From: Chris Moore [REDACTED]
Sent: 12 May 2021 09:27
To: Kathryn Welch <Kathryn.Welch@arun.gov.uk>
Cc: Francesca Lester [REDACTED]
Subject: Extension and Alterations - 22 Tudor Close, Middleton, Bognor Regis - M/47/21/HH.

PROPOSED ELEVATIONS

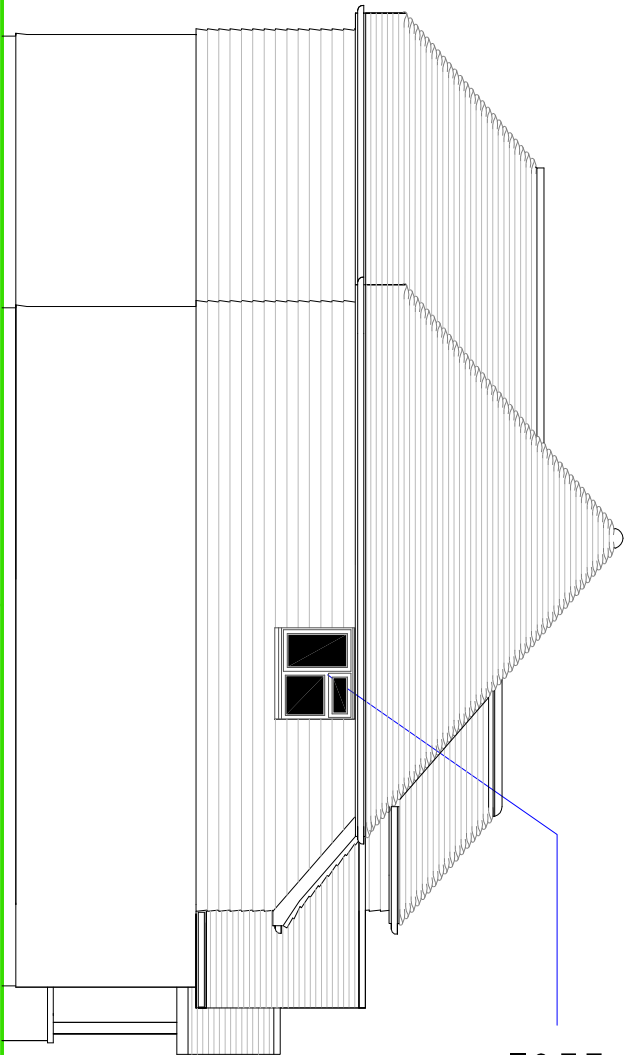
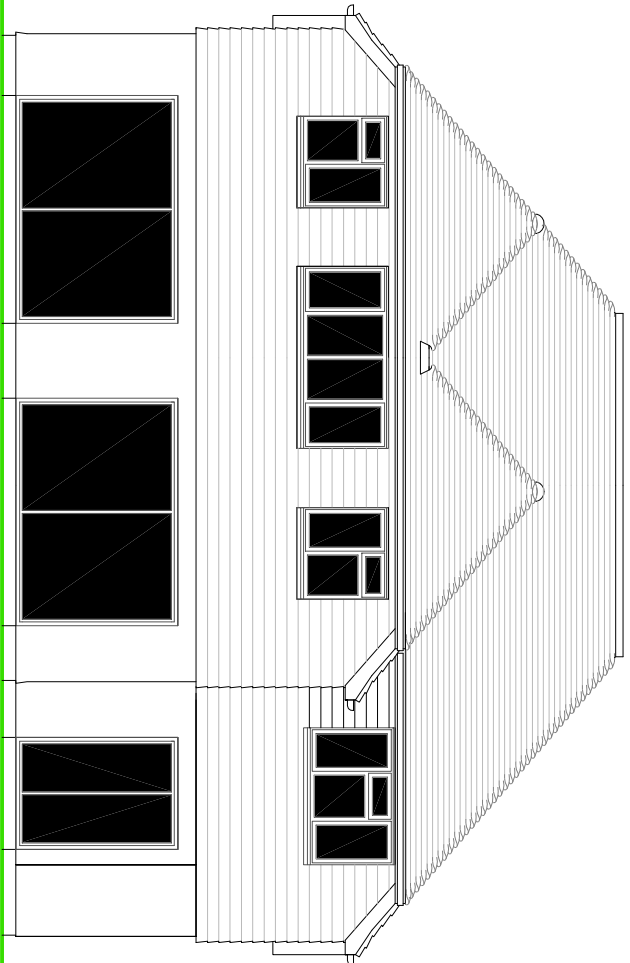
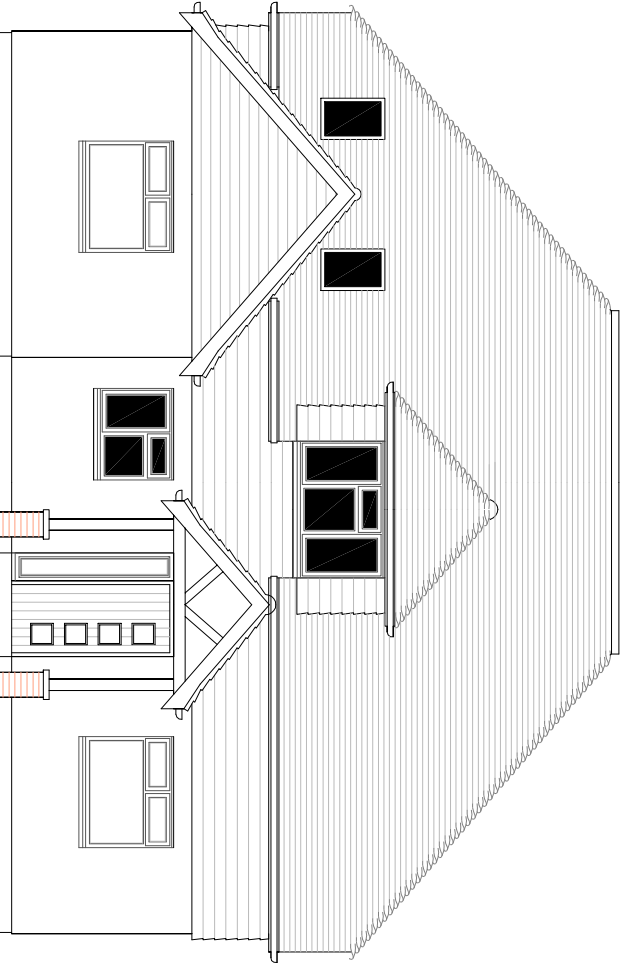
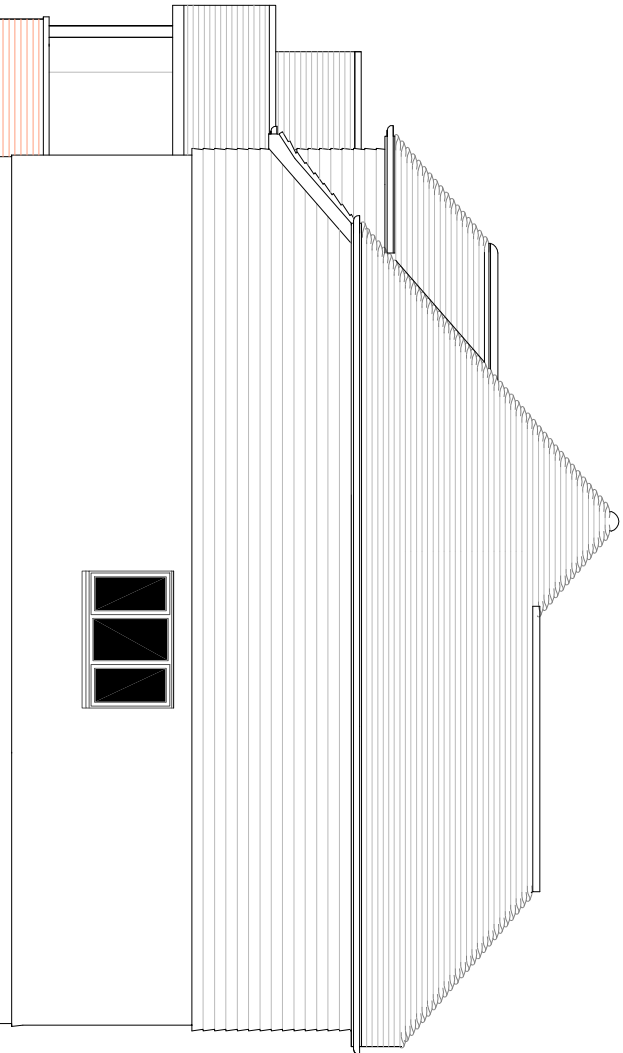
- Loss of privacy and size of windows proposed. Overlooking into rooms in their house.
- Not in-keeping with the existing 2 storey house to the left.

- Harmful rear visual impact and over-bearing.
- Reduced ridge height from previous application but still higher than No. 21
- Concern about increased mass of the building.
- Disproportionate size and number of rear facing first floor windows.
- Overlooking into their rear garden.
- Lower eaves to the front but not to the rear

- Size and height and not in-keeping.
- Overlooking and loss of privacy

The principal rear elevations of No. 91 Middleton Road, sits approximately 44 metres away from the closest point of the proposal, nearly twice the accepted separation distance for two storey properties. Whilst there can be some loss of privacy, no more than accepted design guidelines would allow.

The mass of the building, considered important from the streetscene has been sensitively considered, amended and agreed in principal with the previous case officer following the refusal of the original application. The rear mass of the building, accepted that it is greater than the front, allows for the needed accommodation for the applicants family needs.

The size, positioning and number of windows in the rear elevation are considered in proportion and sympathetic to the design of the building.

As regards the overlooking into the garden of No. 23 Tudor Close, these would be oblique views only and entirely in-keeping with accepted planning principles of design.
